Recommendation Report for Works to Tree(s) on trees subject to a Tree Preservation Order (TPO)

REF NO: AW/117/26/T

LOCATION: 31 West Drive
Aldwick
PO21 4LY

PROPOSAL: Reduce height to 11-12m and reduce spread to 4-5m to 1 No. Sycamore tree (T1).

Photographs of Sycamore, outside 31 West Drive, Aldwick Bay Estate

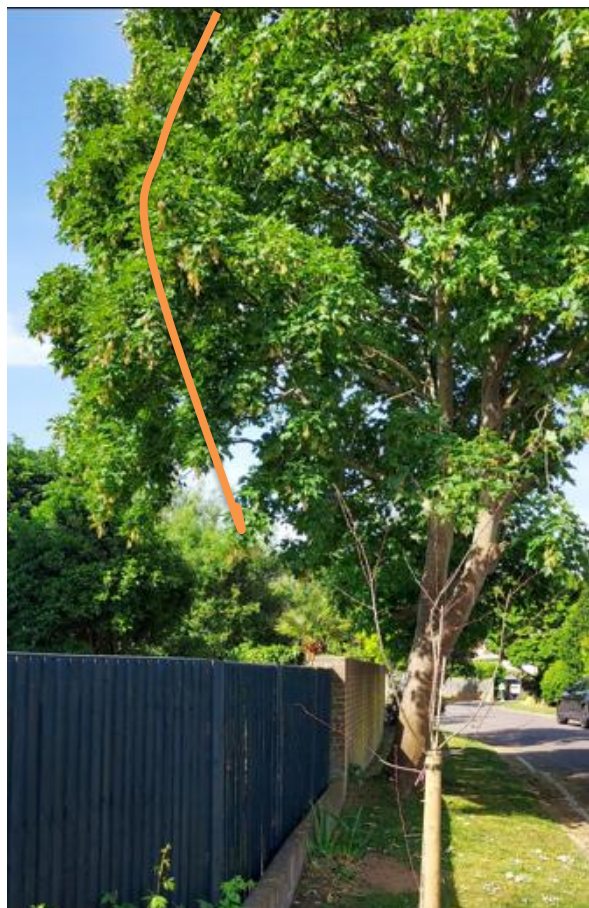
The extent of crown spread pruning is minimal, as limited to that which is illustrated on the submitted photographs; those can be used to ensure compliance with any consent. A reduction in radial crown spread will only occur on the south aspect.

I measured the tree as approximately 12.5m high and so the proposed reduction in height will be minimal, thereby retaining a natural appearance.

- 1 Part a) Where whole branches are to be removed and final cuts made close to the trunk or branch union they are to be made as shown in Figure 2 of BS3998:2010

Part b) Where branches are to be shortened back the final cuts are to be made at the correct angle shown in BS3998:2010 and adjacent to a live bud or lateral.
